Our Ref: 689/013
Your Ref: 18/01333/F
Date: 11th October 2019

VARIATION OF CONDITIONS FOR PLANNING PERMISSION 18/01333/F

We write to submit information for the variation of conditions attached to planning permission 18/01333/F. The application was for the extension to existing Technical Site to provide new employment units comprising flexible B1(c) light industrial, B2 (general industrial), B8 (storage or distribution) uses with ancillary offices, storage, display and sales, together with associated access, parking and landscaping. The application to vary the conditions has been made via the planning portal under reference PP-08147840.

TITLE:  
**Building C Proposed Elevations**

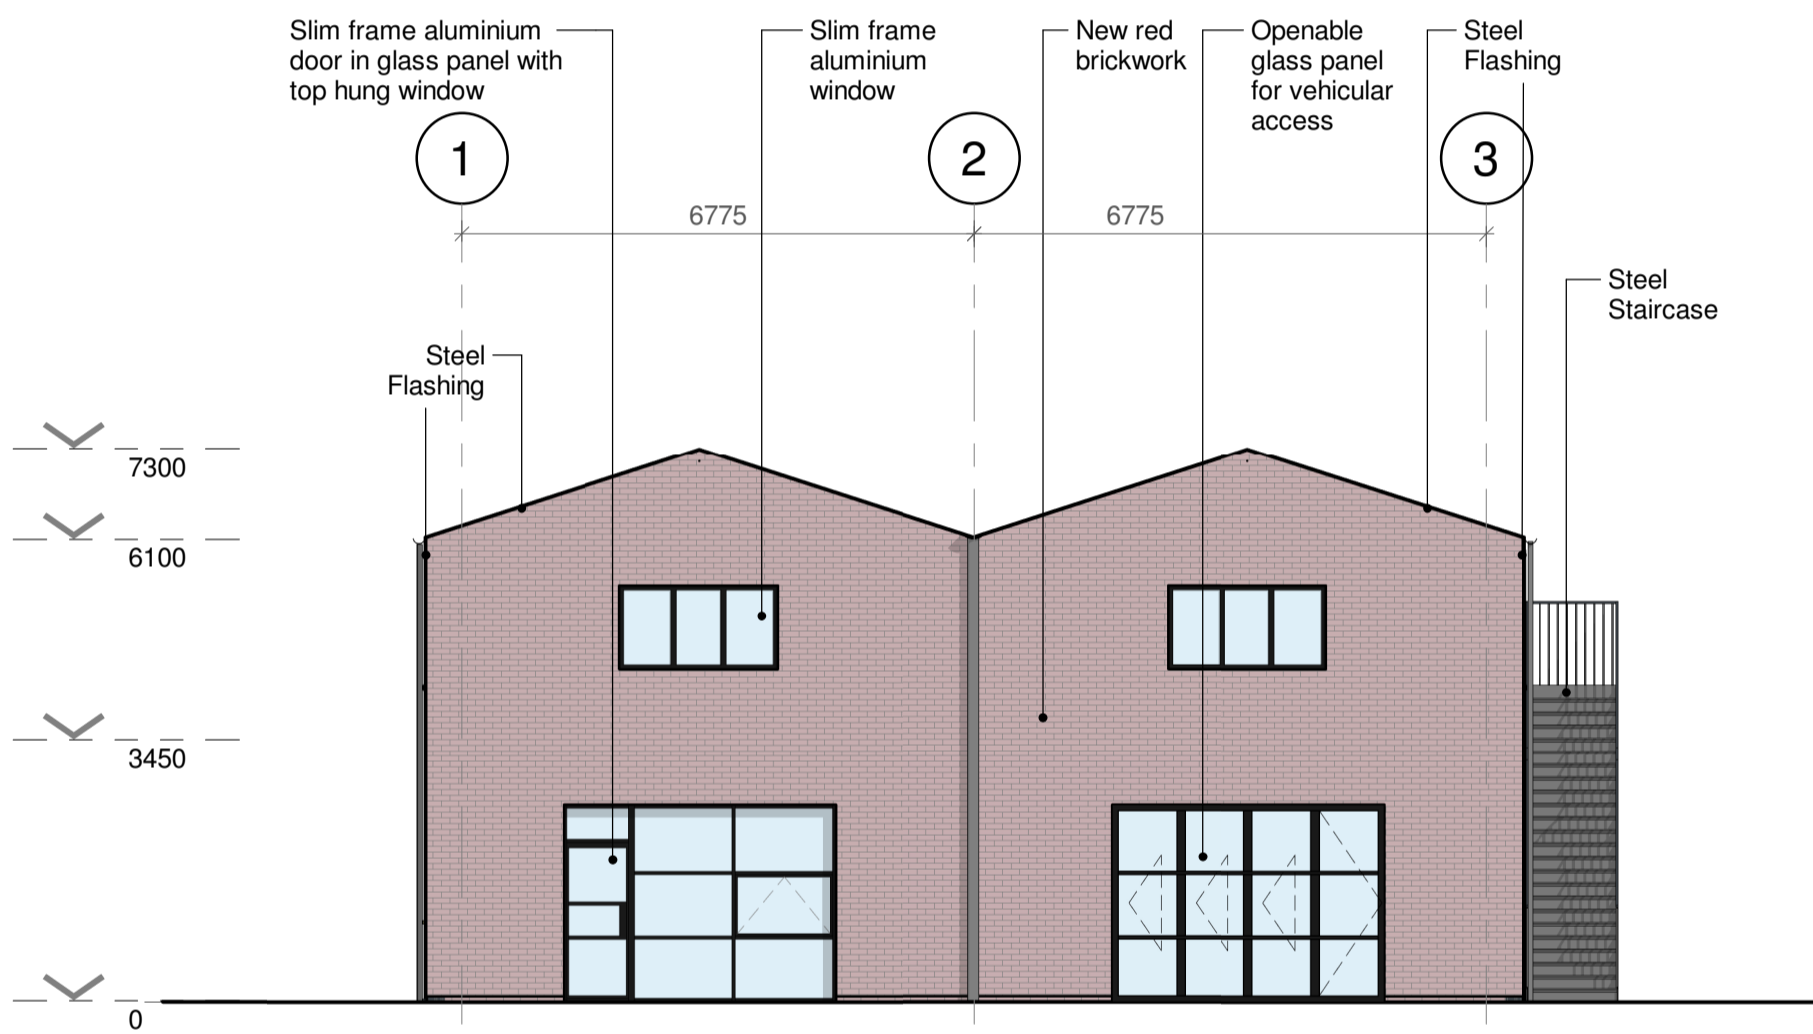
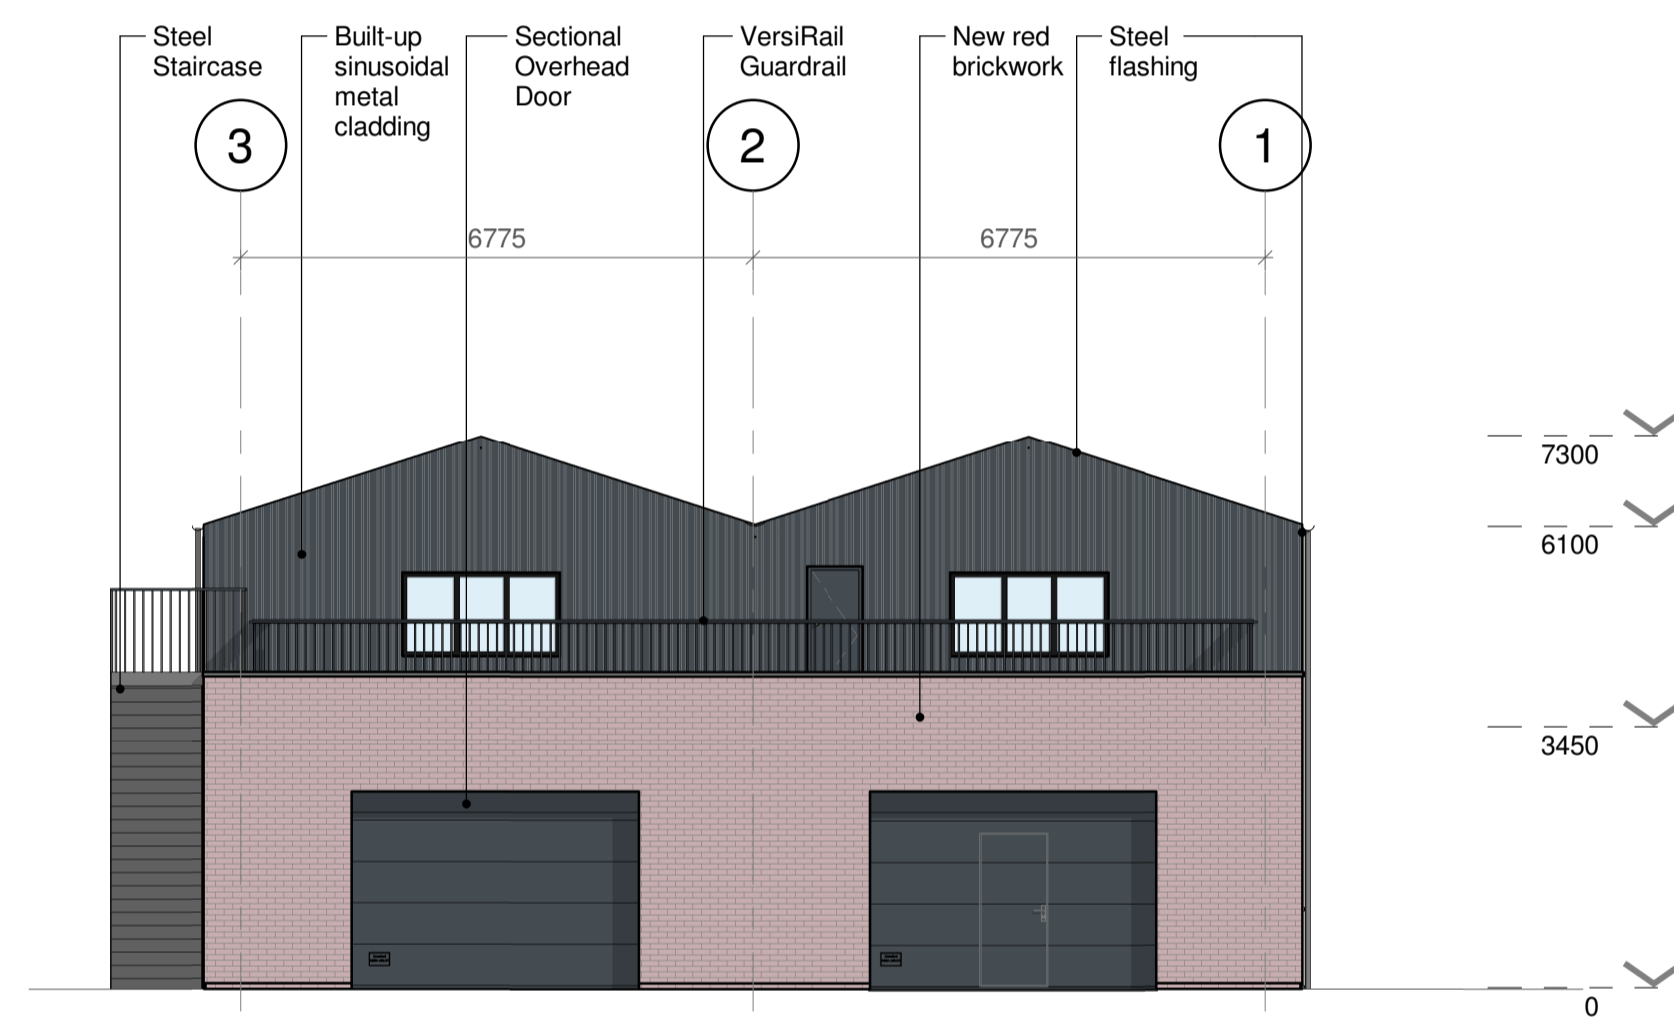
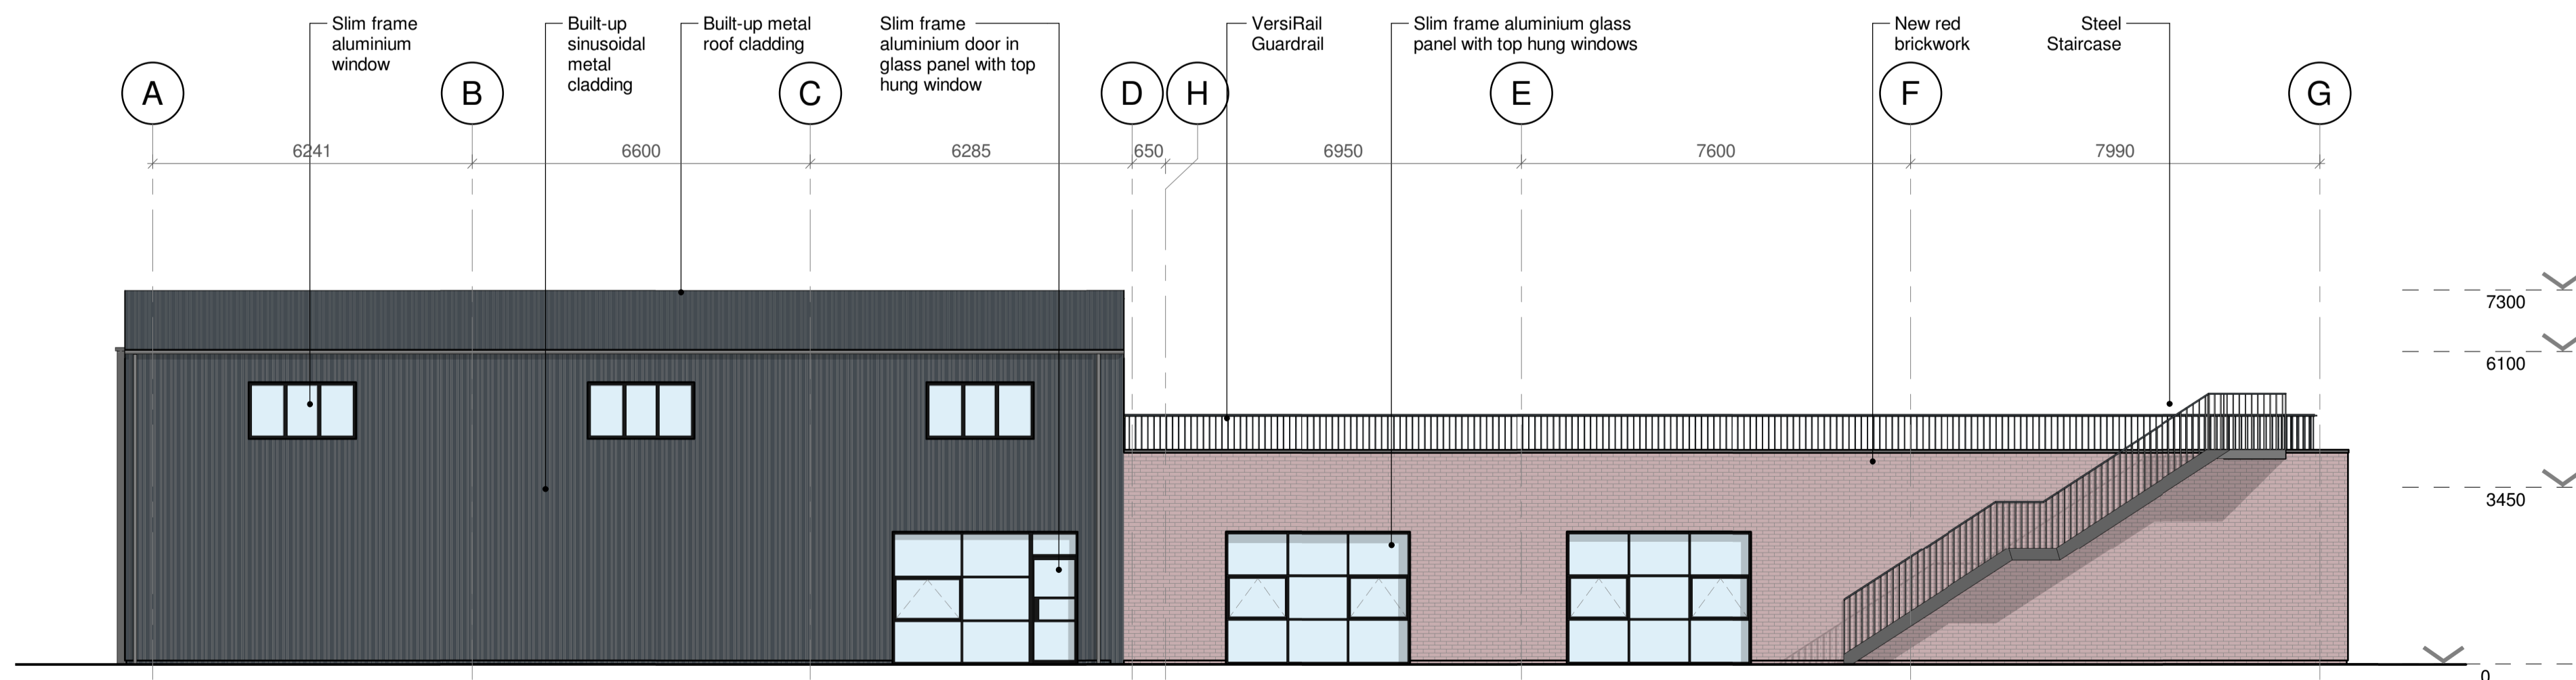
Drawing / Unit		Changes
		Locations of car parking bays
		A new staircase for Unit C added
		Future charging points introduced
		Infiltration basin shape changed
		Surface Treatment amendments around buildings
Unit A	GF	A sectional overhead door replaced with fully openable glass panel
		Two high level windows added
Unit B	GF	A glass panel with access door replaced with fully openable glass panel
		A sectional overhead door replaced with a glass panel with access door
		A sectional overhead door removed
		A glass panel with access door replaced with a sectional overhead door with wicket door
		An escape door added
		An escape door relocated
		Staircase relocated
	FF	A window relocated
		A window size increased, and window relocated
	Roof	Four rooflight added
		One rooflight relocated
		One rooflight size decreased
	Unit C	GF
External staircase and balustrade added		
FF		Two windows added
		One access door to terrace added

Perimeter handrail added
Unit D	GF	A glass panel with access door replaced with fully openable glass panel
		A glass panel replaced with fully openable glass panel
		Two sectional overhead doors replaced with two glass panels
		A glass panel added
		A glass panel relocated
		A glass panel with access door removed
		An escape door added
A sectional overhead door replaced with a glass panel with access door
